From: alan.story@hertfordshire.gov.uk
To: [Planning](#)
Subject: Planning application 6/2018/3182/FULL - 12 Harpsfield Broadway
Date: 14 January 2019 11:14:11

District ref: 6/2018/3182/FULL

12 Harpsfield Broadway

Notice is given under article 18 of the Town and Country Planning (Development Management Procedure) (England) Order 2015 that the Hertfordshire County Council as Highway Authority recommends that permission be refused for the following reasons:

Ground Floor Plan-Proposed

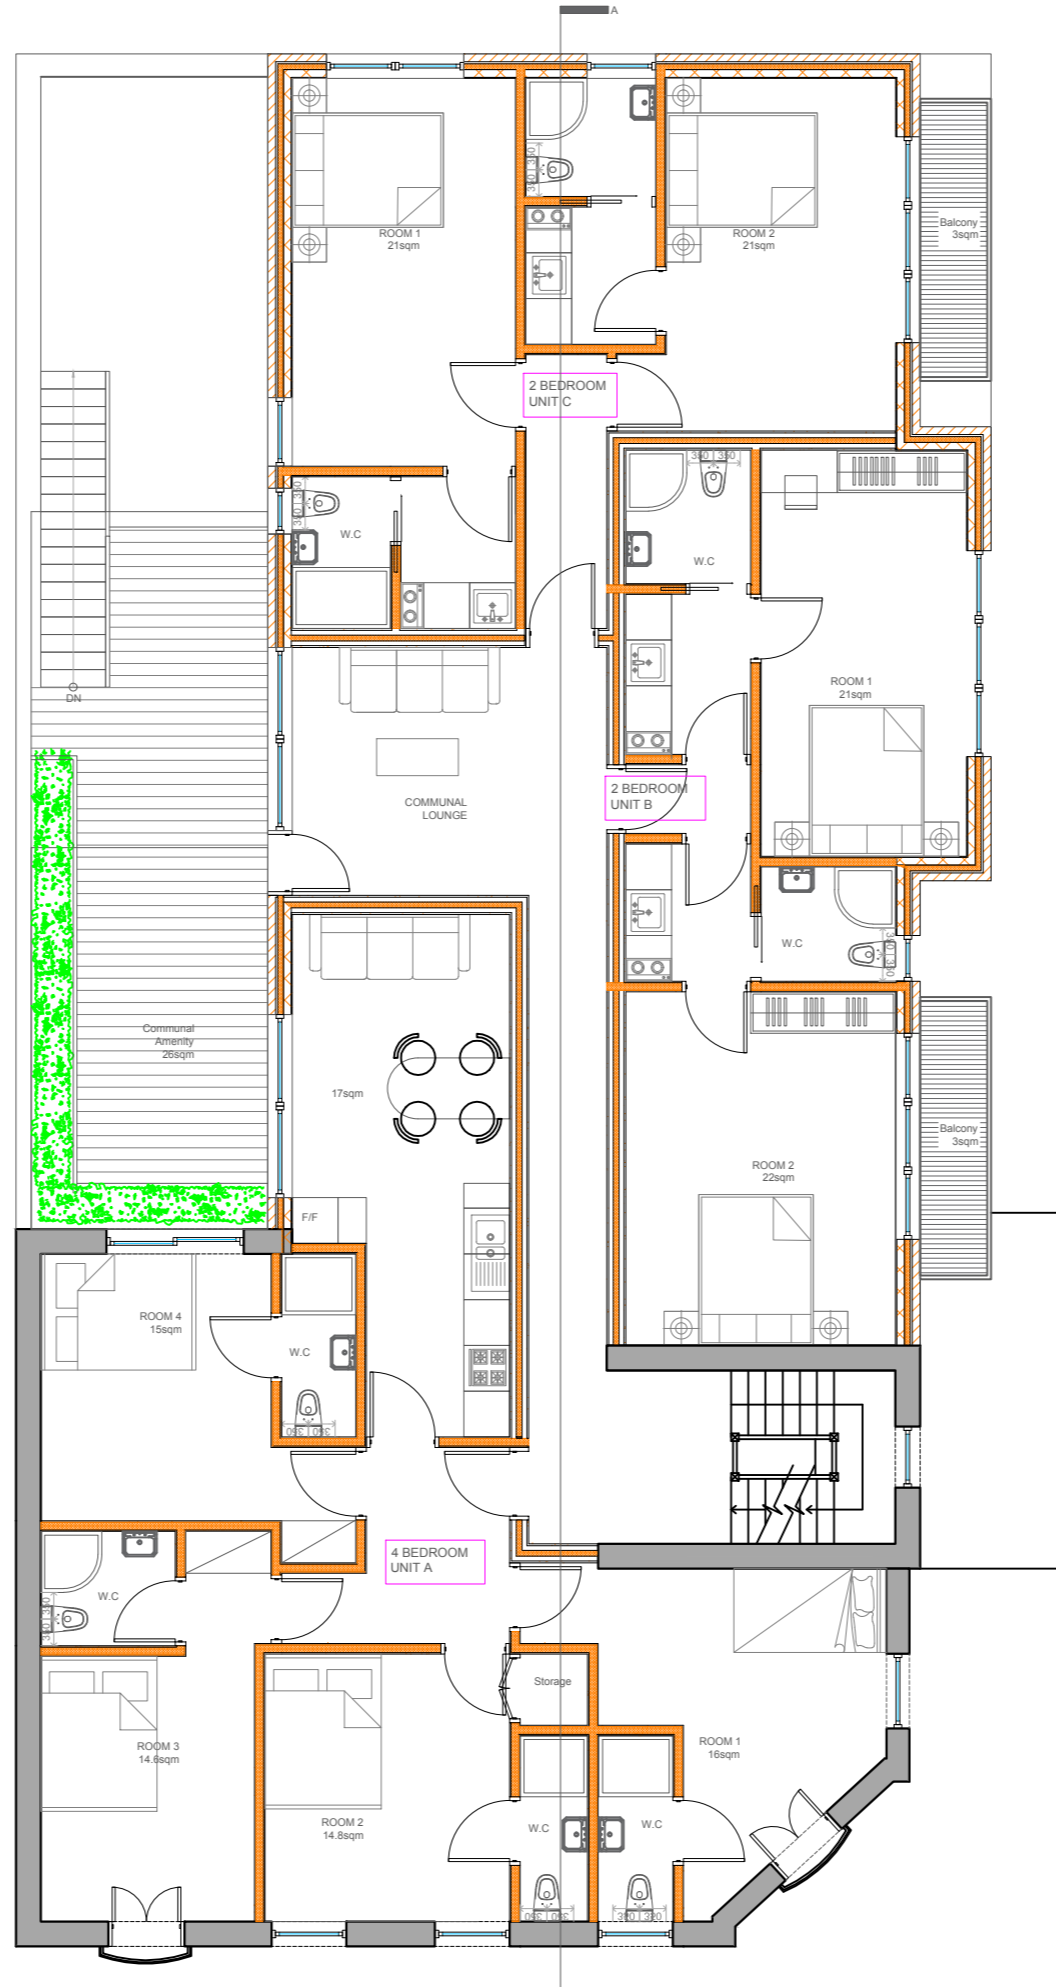
1) Jetline Way is subject to a TRO for its' length preventing access by any form of vehicle other than a bus. The proposed access is inaccessible by legal means, and therefore – if permitted – would result in illegal vehicle movements contrary to the provisions of the Highway Act.

Jetliner Way is a local access road, linking Comet Way with Tablin Way / Goldsmith Way and also serves the bus interchange of the Hatfield Business Park. Noting the bus station presence, it is necessary to observe that access to this area is restricted by a Traffic Regulation Order. Such Order being made under the Road Traffic Regulation Act 1984 by HCC, order no. 7319, dated 12 February 2009.

The effect of this order is to prohibit the movement of any vehicle other that defined in the order as a bus, between the length of Jetliner Way, Hatfield from its' junction with the north west kerbline of Harpsfield Broadway to its' junction with the south east kerbline of Thamblin Way a distance of approximately 64 metres.

Development proposals include the provision of a dropped kerb within this area, shown to facilitate access to 3 off-street parking spaces. This access may not legally be reached by a private car given the above Traffic Regulation Order. I therefore object to the vehicle crossover.

In terms of site layout, it is necessary to consider the bin store in relation to the legal point of collection (Harpsfield Broadway). Such a distance is within the maximum carry distance, but the views of the LPAs own client services should be considered in this regard. Deliveries to the site would need to be facilitated(as existing) from Harpsfield Broadway and / or shared private driveway to the rear.

Cycle parking is provided and is well located within the site for ease of access, and this is welcomed and encouraged by the Highway Authority.
